ENG-PUDSP19005-R4b-PUDSP-Redlines Summary_Markup Summary

TYPICAL STREET CROSS-SECTIONS

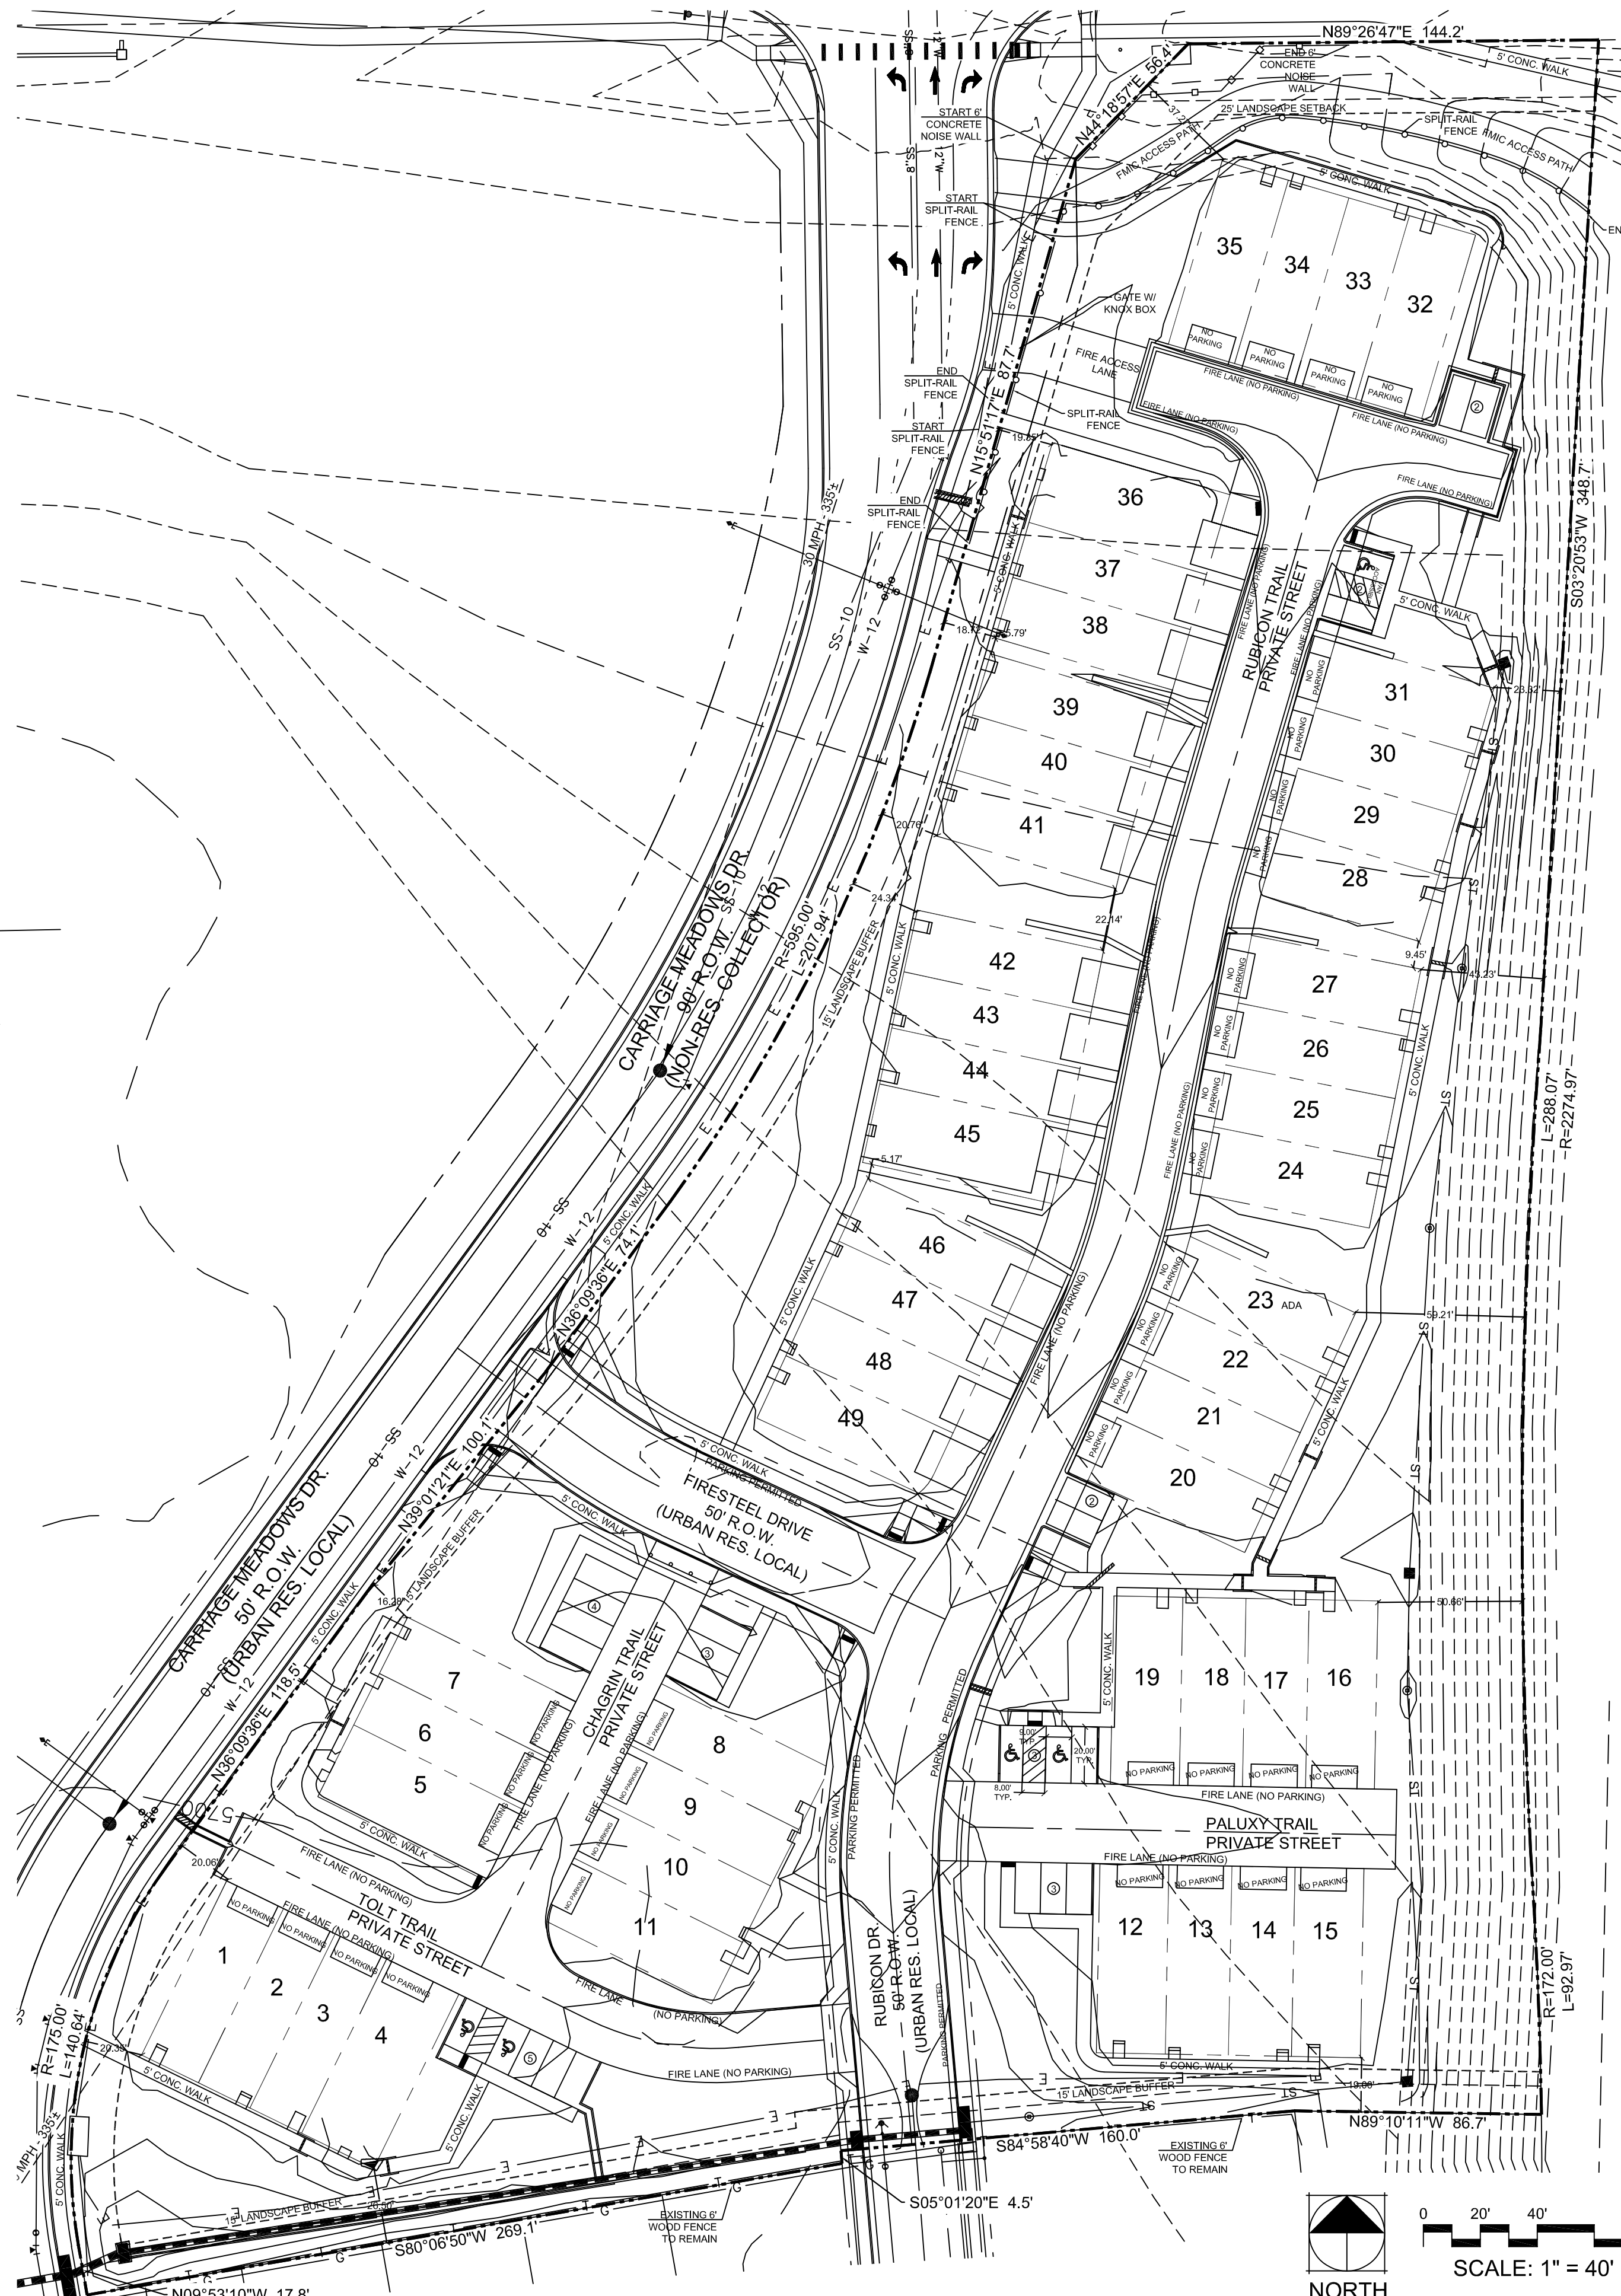
Not required for a private road

private

SITE SPECIFIC NOTES:

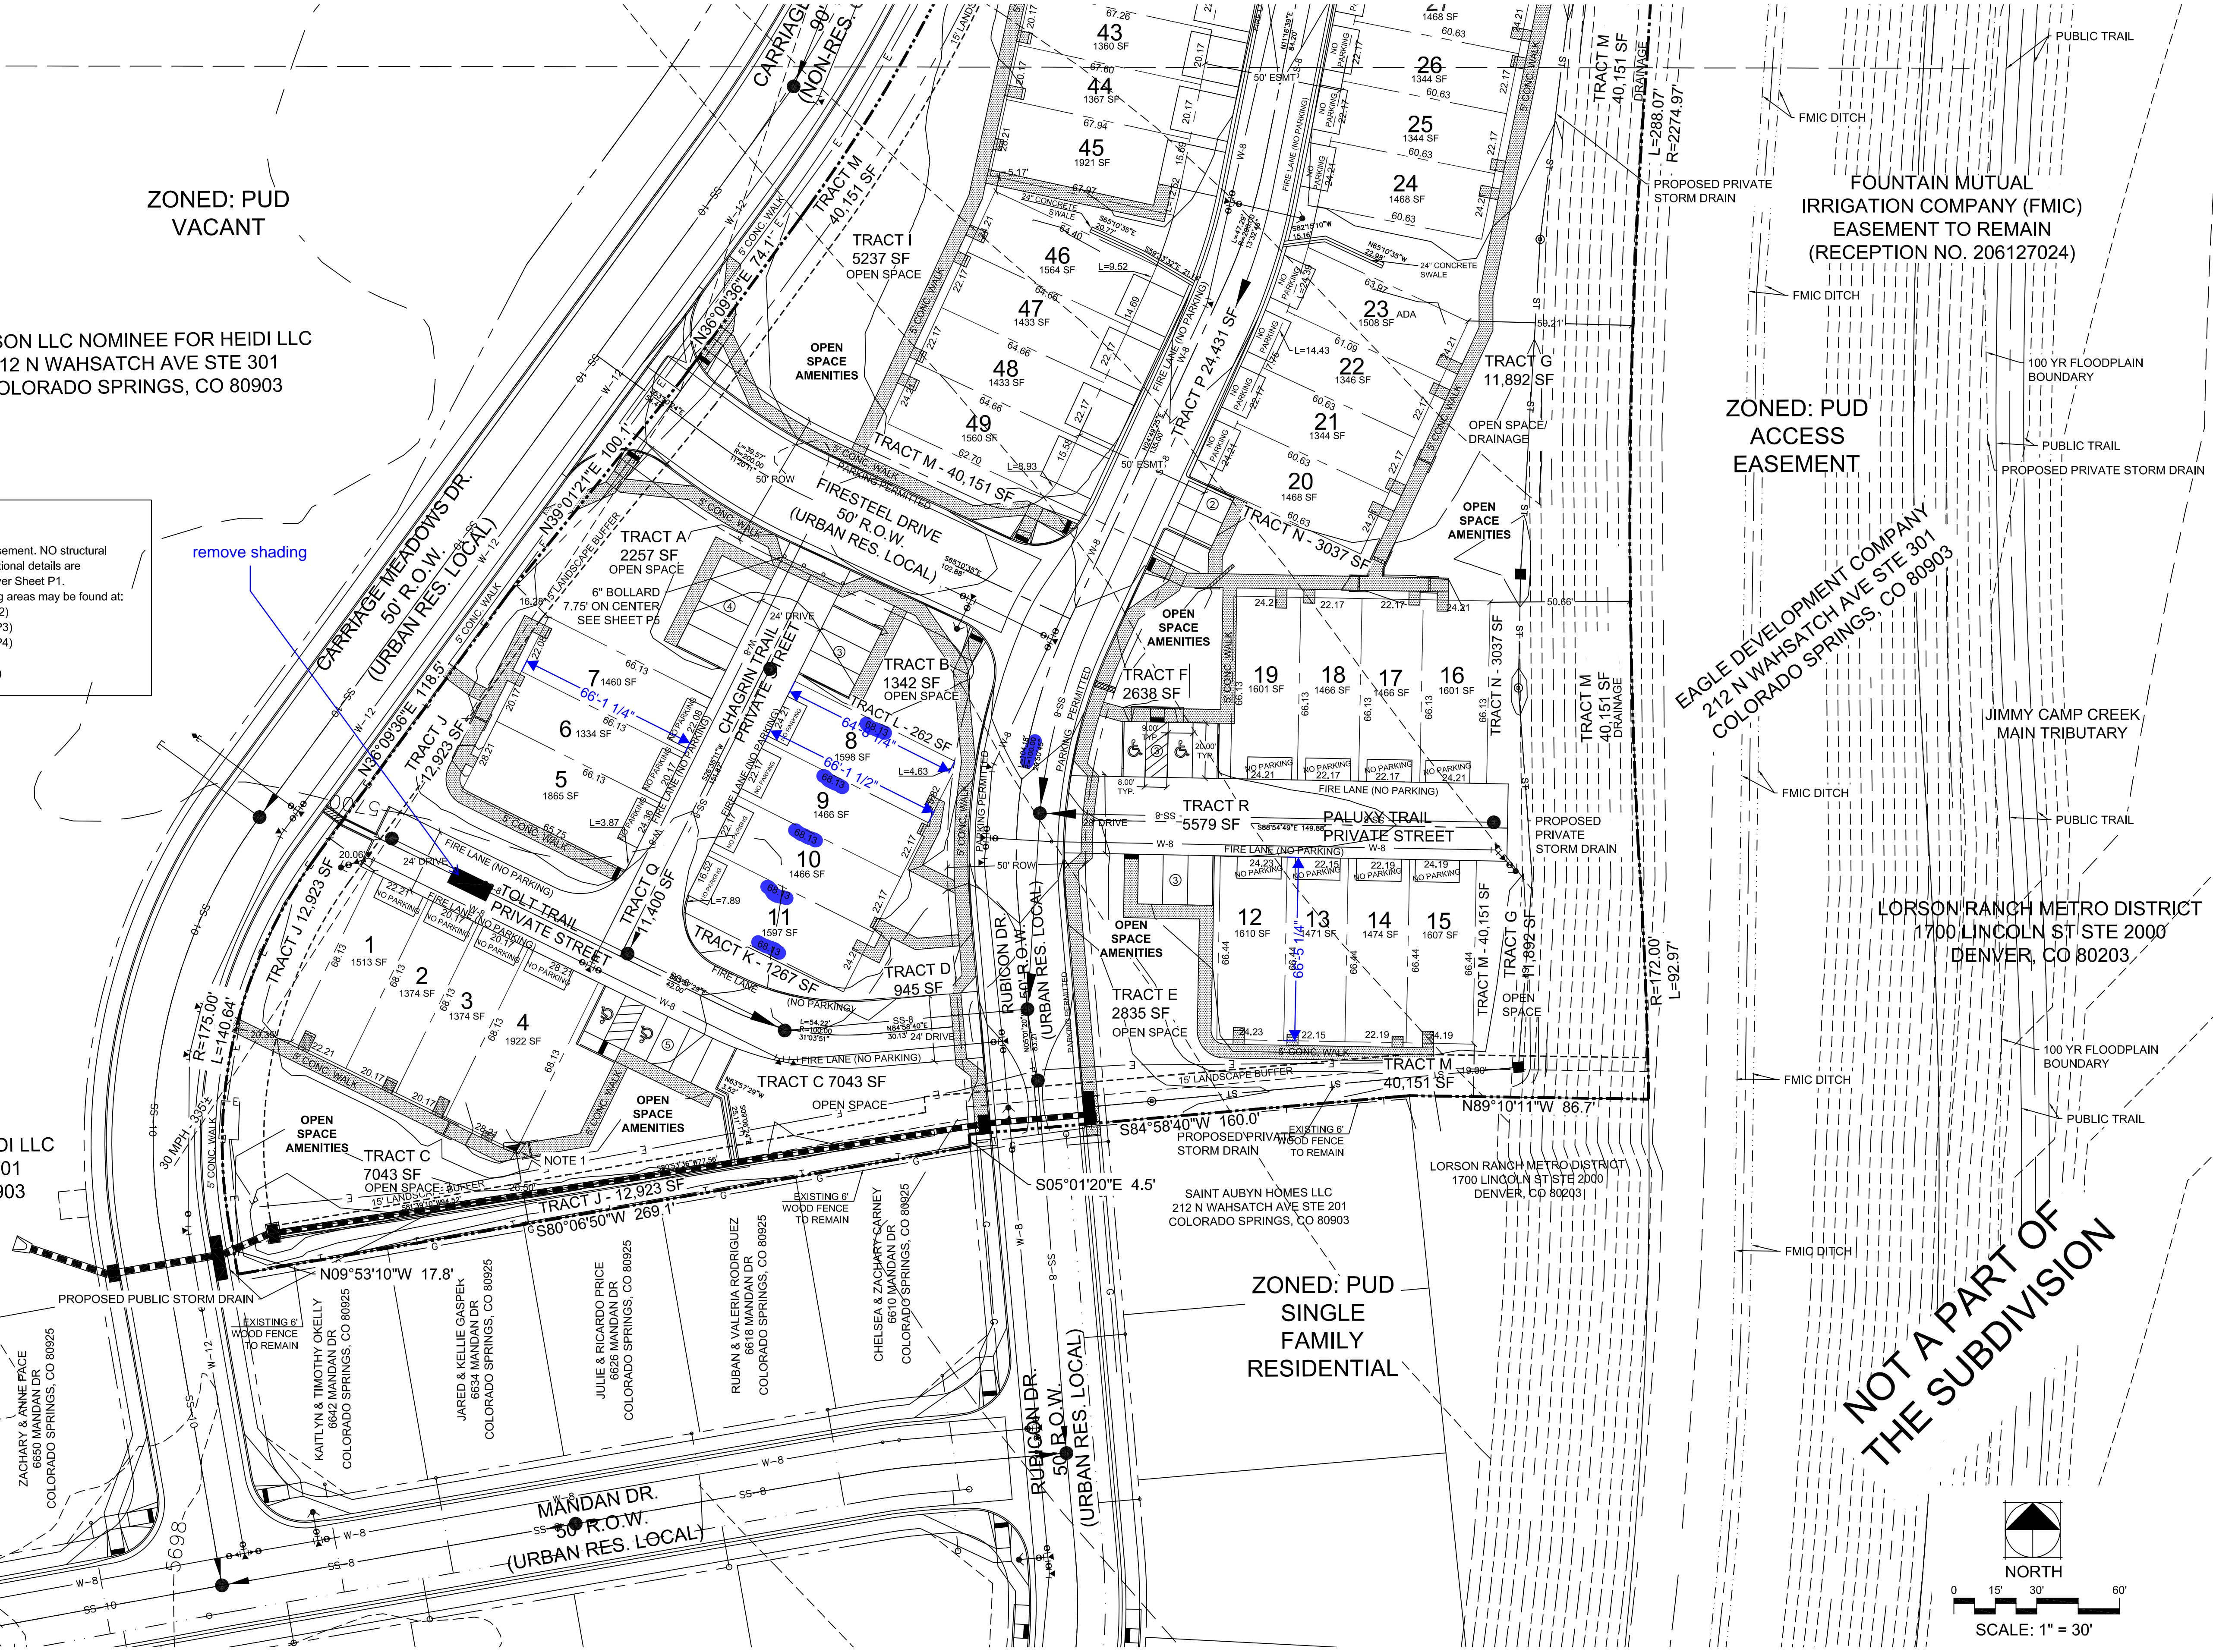
remove shading
